Able Marine Energy Park Material Change 2 Case Team
National Infrastructure Planning
AbleMarineEnergyPark@planninginspectorate.gov.uk

MMO Reference: DCO/2013/00020
Planning Inspectorate Reference: TR030006

Planning Act 2008 and the Infrastructure Planning Regulations - Application by Able Humber Ports Ltd for a Material Change to the Able Marine Energy Park Development Consent Order 2014

Deadline 3 Submission

Figure 6.5: Early stage reclamation - Predicted peak increase in depth-averaged suspended sediment concentration above background over a spring-neap cycle

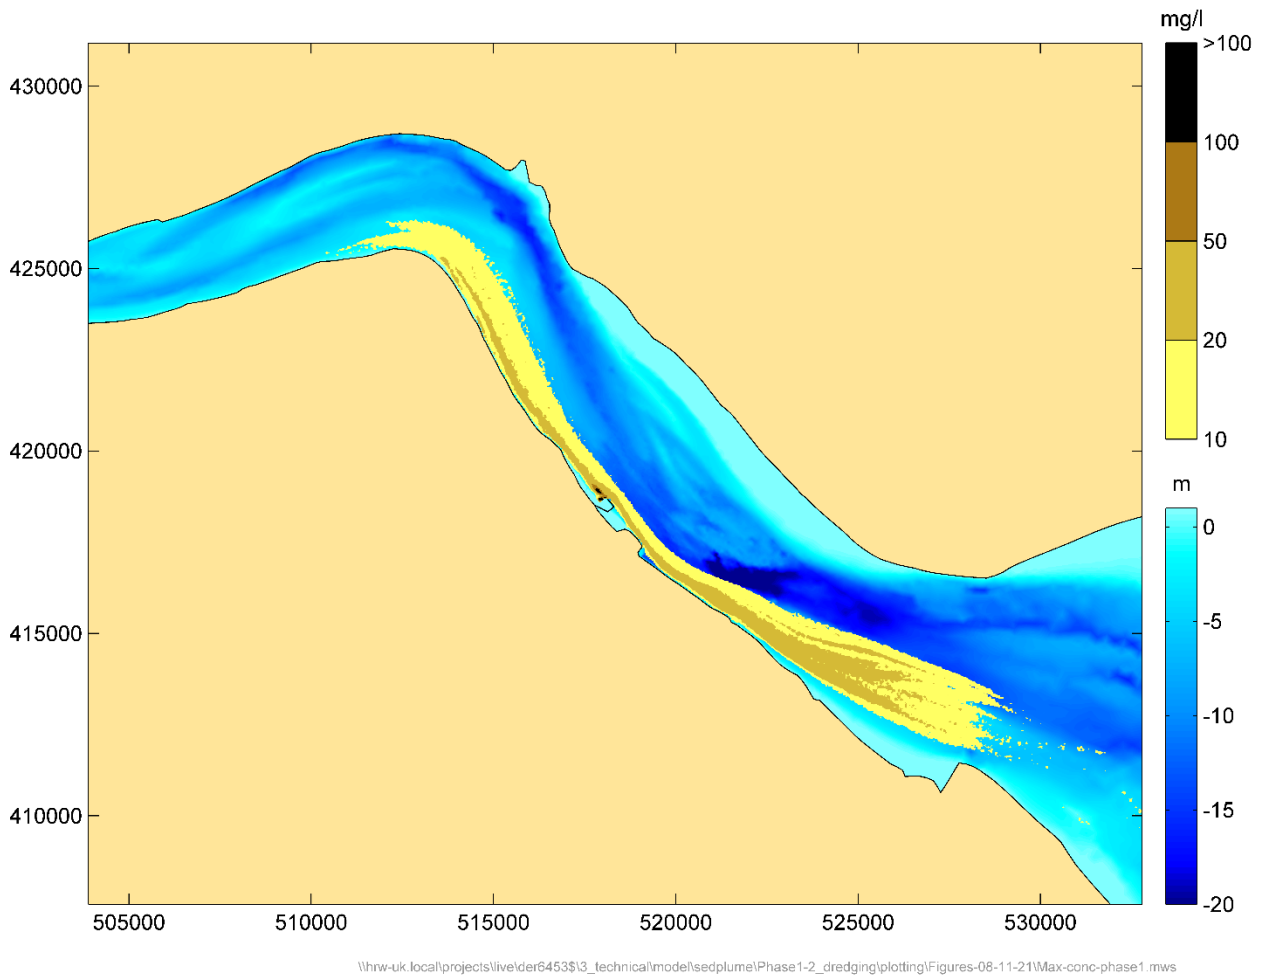
- 3.1 The MMO note that Sections 6.2.1 (early phase) and 6.3.1 (late phase) present data on depth-averaged suspended sediment concentration (SSC) increases, which indicate (absolute) increases over background of up to 50mg/l. The general conclusion is that the absolute increases are low in an estuary context. However, Section 4 (background SSC) lists peak SSC (at various estuary locations around the site) which the MMO consider would be more valuable presented as background values (while minimum values would be indicative of the potential worst case instantaneous change). It can be assumed that the works will occur at 'off-peak' times (i.e., dredging is not likely to occur in excessive weather/flow states associated with peak SSC) so the relative increase over background is not well represented. While the MMO appreciate that the peak value shows that very high SSC is not unusual in the location, comparison with the mean would make a stronger point with respect to the significance of the chronic effect.
